PROJECT NAME: DeMillo's Floating Restaurant & Marina

PROJECT ADDRESS: 25 Long Wharf Portland, Maine 04101

To install an Auxiliary Generator @ DeMillo's to supplement the energy supply to the Marina RECEIVED

Re: DiMillo's Exemption Application for WINDSPIRE Wind Generator

PROPOSED POLE TYPE PROTECTOR FOR DIMILLO'S WINDSPIRE BASE

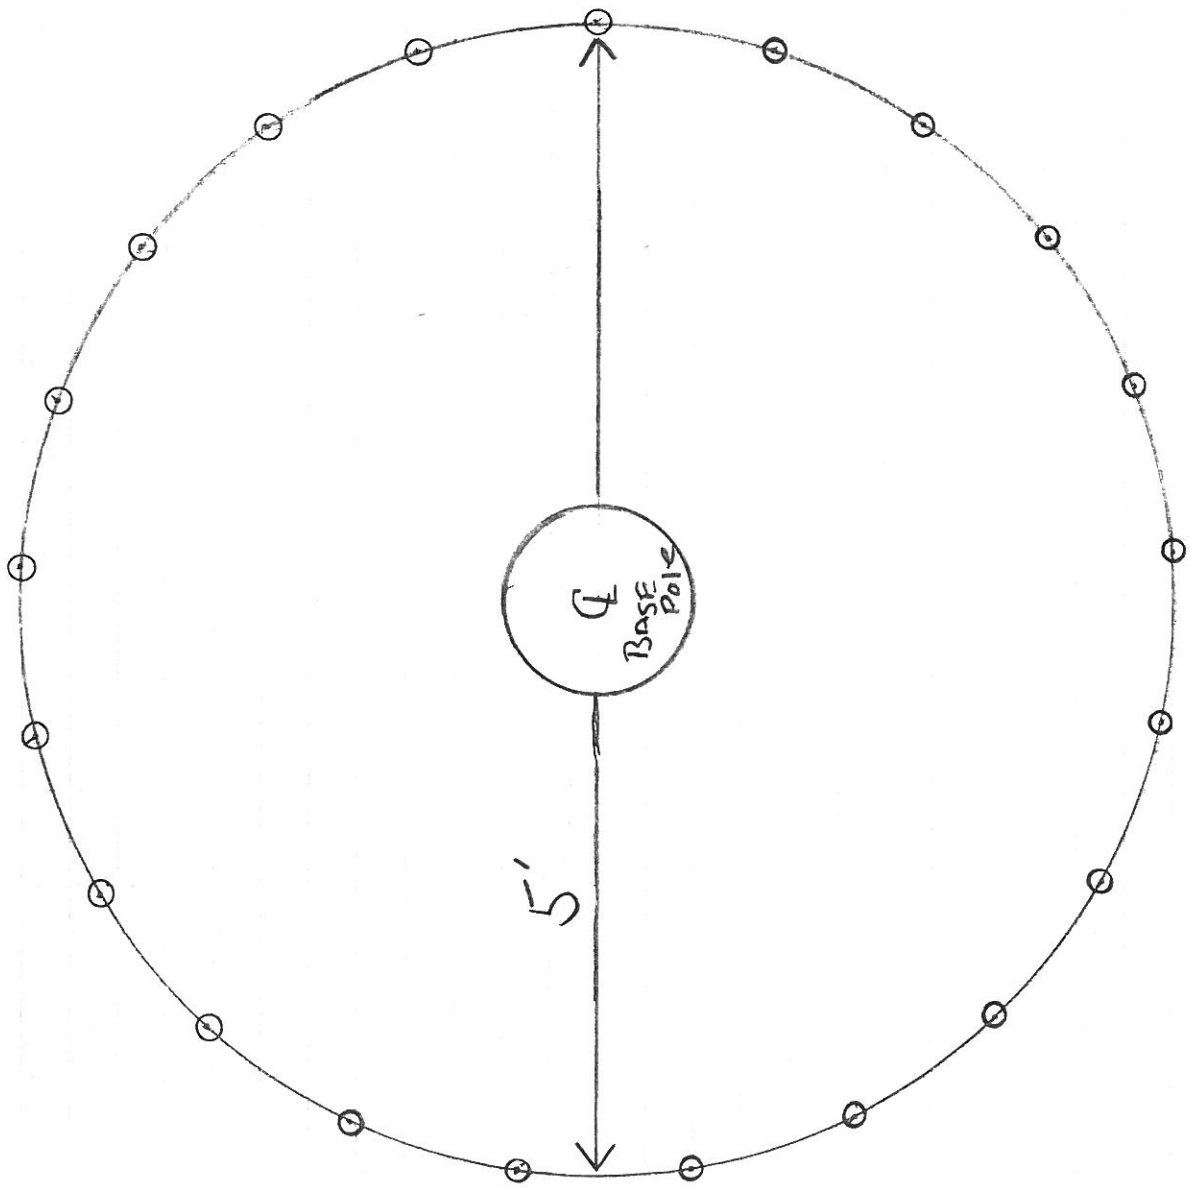
1. 5-6 ft high tubular railings (similar to the blue painted ones that are there but higher) around the generator base and securely attached to the existing railing and chain link fencing on the waterside to prevent unauthorized access to the generator base;

- The revised sketch plan includes "5-6 ft high tubular railings similar to existing" and indicates where they will be located around the base. While no details of the fencing or its connections to existing fencing are included (I had asked for clarification of the spec), I suggest that we grant the exemption subject to a condition that requires submission of the railing specifications for review and approval.

Re the fencing Barbara will let you know if OK- also it needs to follow the line of the approved fence and the benches need to be outside it.

I have had reports that you have benches underneath the *Windspire* and no fencing despite that being a condition (circular fencing such as around trees, 10ft in diameter- see attached).

- a condition that requires submission of the railing specifications for review and approval (?prior to issuance of building permit? JF checking re this);
- a condition that they obtain the required building permits prior to installation.
